**Re: Existing Tank Application: BRES2004-0030**  
**219 Morgan Farm Drive Lillington NC 27546**

An attempt was made to evaluate your property for the purpose of issuing an Improvement Permit. The evaluation could not be completed for one or more of the following reasons.

Lot 14 MORGAN FARM  
219 Morgan Farm Drive  
Lillington NC 27546  
0.71 Acres

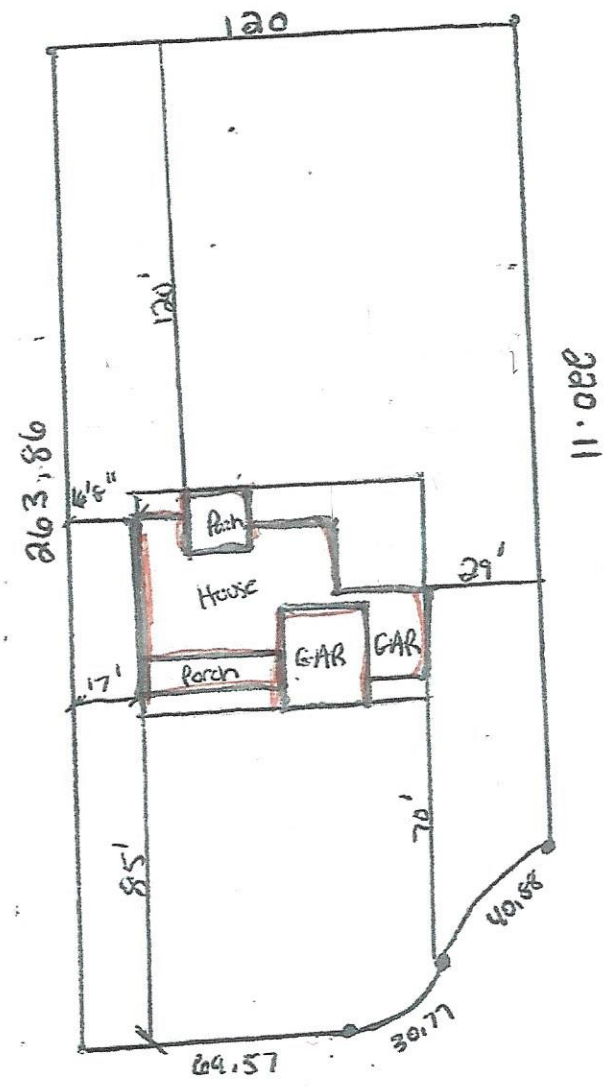
- 1. Use pink flags to mark property lines and irons that are set by surveyor need to be visible. (*\$25.00 fee incurred*)
- 2. Use orange flags to mark house corners (*\$25.00 fee incurred*)
- 3. Directions not clear to property (*\$25.00 fee incurred*)
- 4. Property needs only brush or vegetation removed
- 5. Driveway not shown on site plan
- 6. Backhoe pits required
- 7. Other- **Pool setbacks required off SFD and property line to pin down pool. Site plan proposal shall be revised to reflect exact placement of pool. Relocated system shall meet 15ft pool setbacks (sys. Flagged onsite). Call inspector with any placement questions.**
